WEST SUSSEX COUNTY COUNCIL CONSULTATION

TO:	Arun District Council - FAO:
FROM:	WSCC - Highways Authority
DATE:	17 March 2021
LOCATION:	Land West Of Fontwell Avenue, Eastergate, PO20 3RU
SUBJECT:	AL/9/21/DOC Approval of details reserved by condition imposed under ref AL/117/18/PL relating to Condition No 3 - Construction Management Plan.
RECOMMENDATION:	Advice

CMP plan

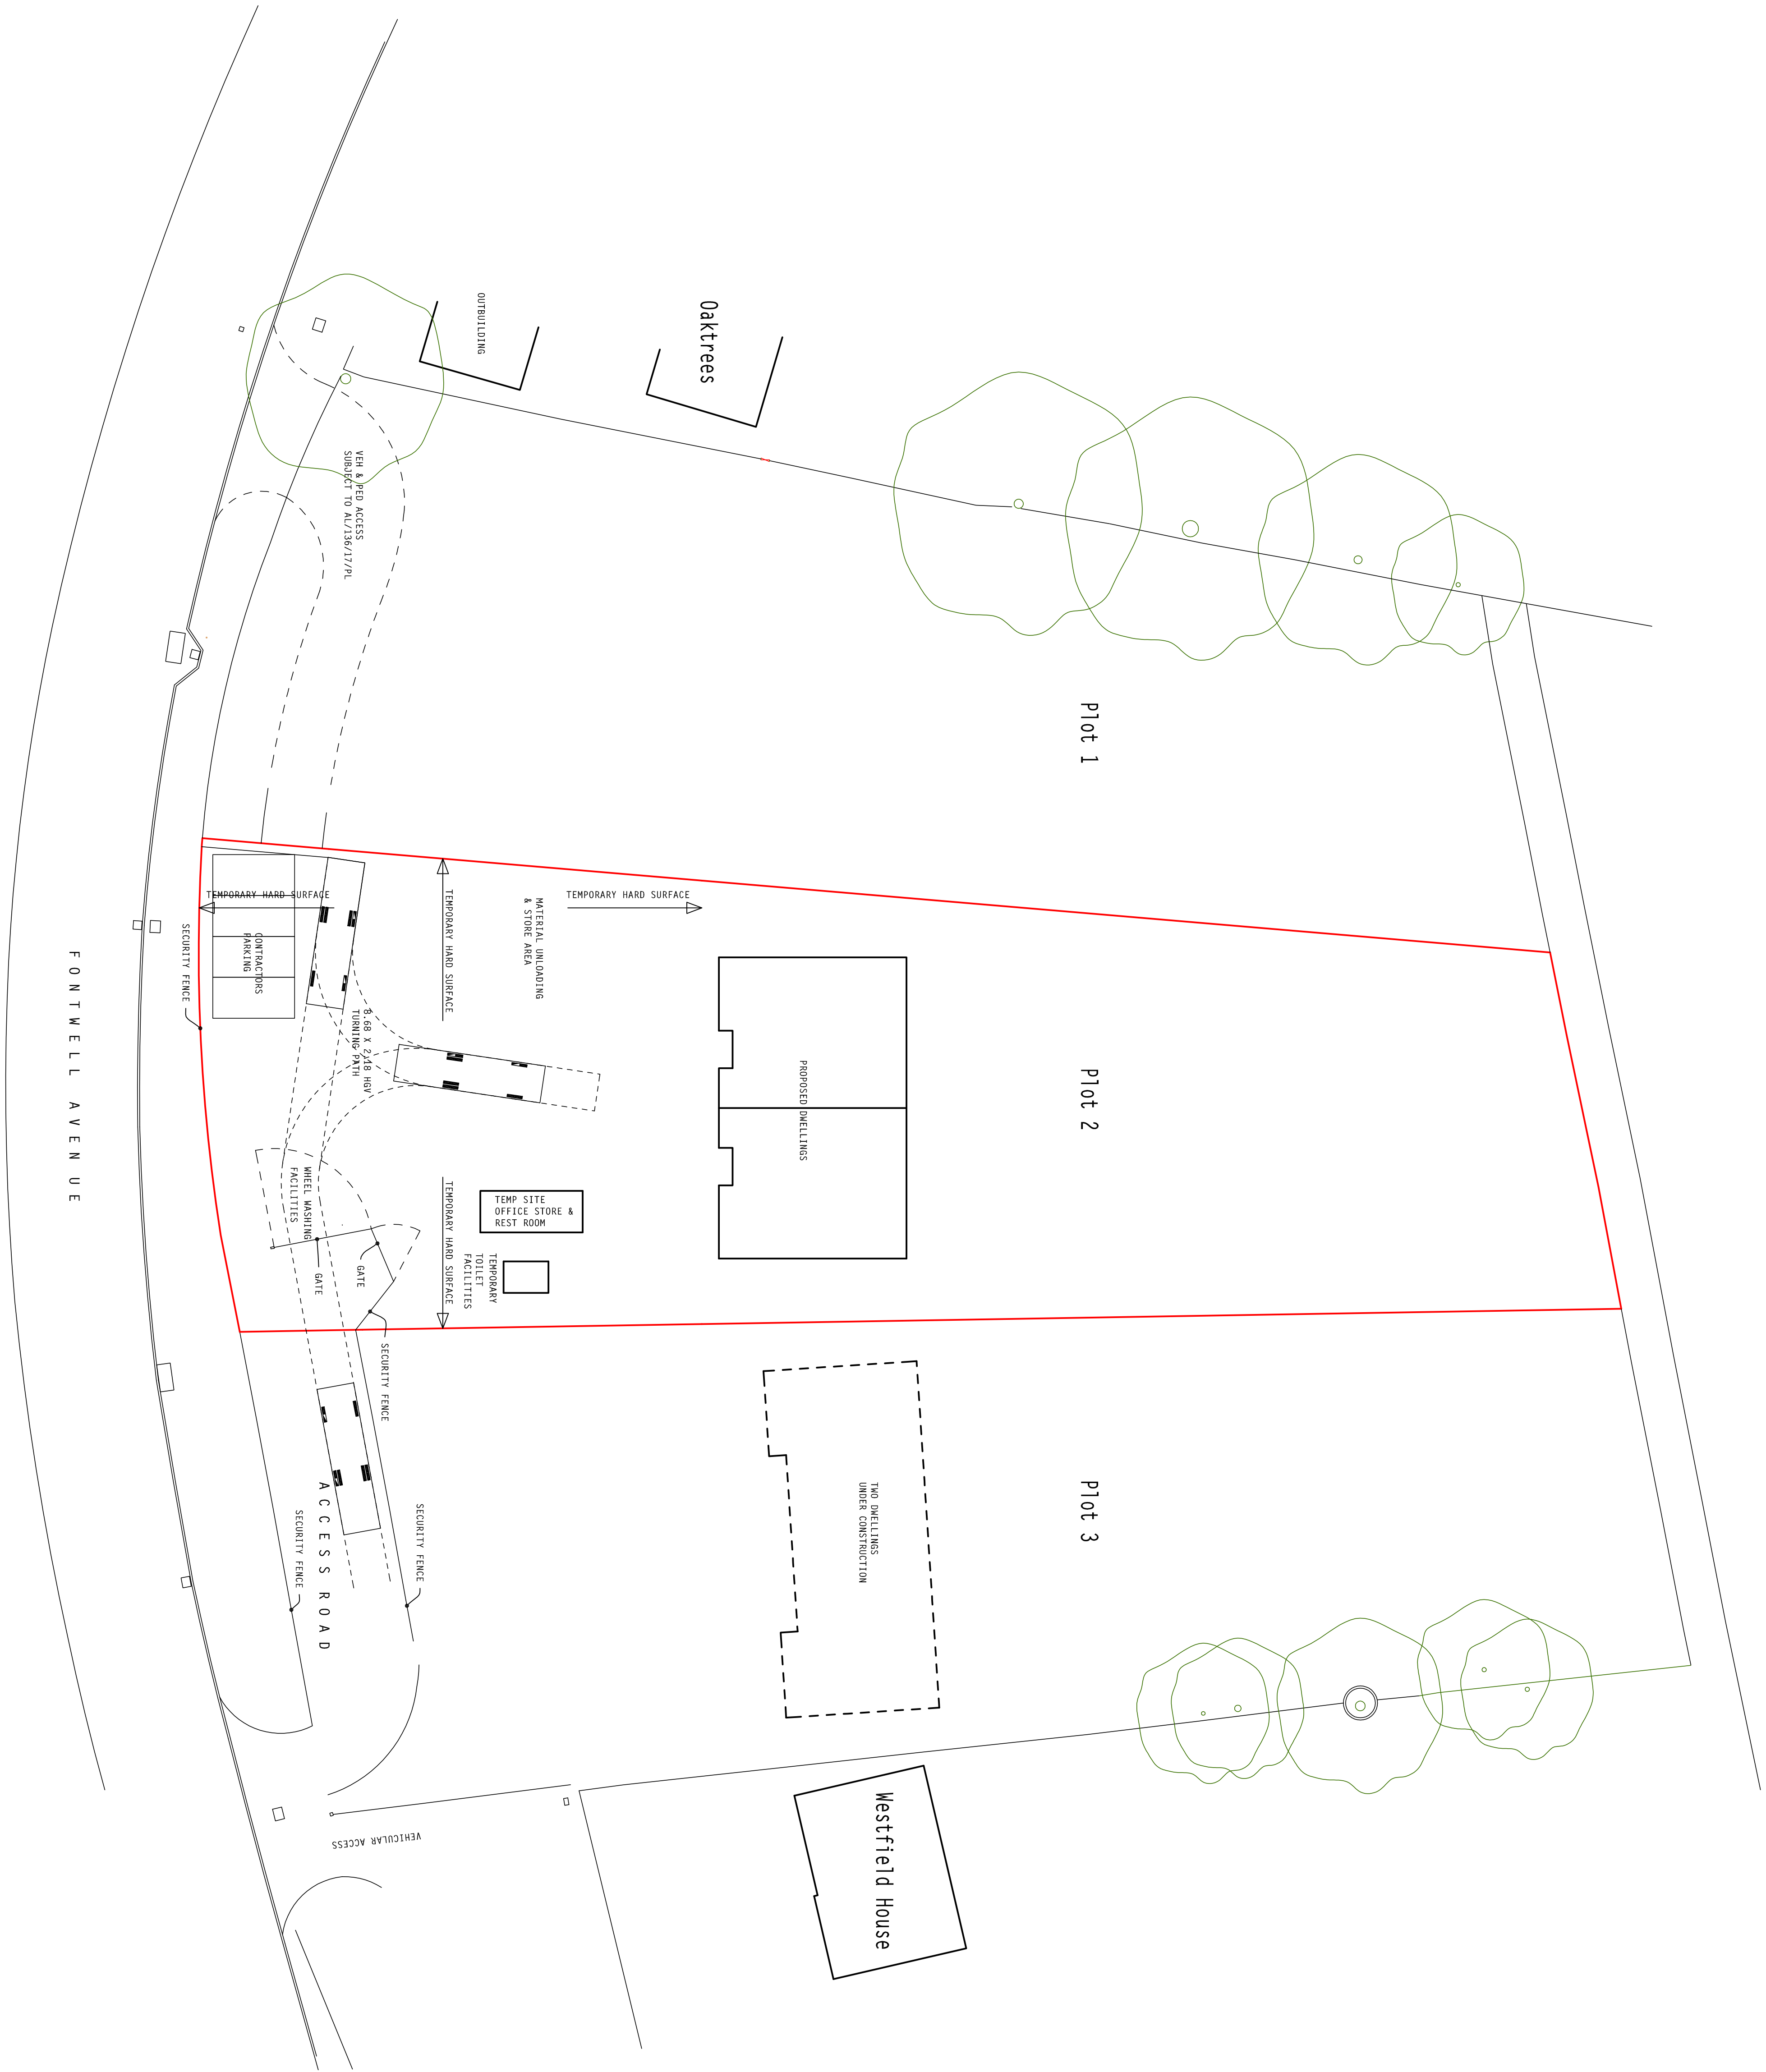
The applicant has clarified the largest vehicle anticipated would be similar to fire appliance and swept path tracking plans have been provided to show that this can turn on site. Plans submitted under AL/117/18 show that this manoeuvre is possible from the public highway. Any over-run of the verge by larger vehicles would expect to be made good when the access is created. The applicant is reminded of this requirement to enter in to a legal agreement with WSCC highways for the access works.

Areas for contractor parking, loading and unloading and plant/material storage has been noted, along with wheel washing facilities along the internal access road.

The LHA are satisfied with the demonstration that the northern access in its current form is suitable for construction vehicles. Nevertheless, it is also noted that condition 6 of AL/117/18 requires that the northern most access be constructed prior to any development taking place. The Local Planning Authority may wish to consider whether construction should commence without satisfaction of condition 6 or whether the condition needs formal removal/ amendment.
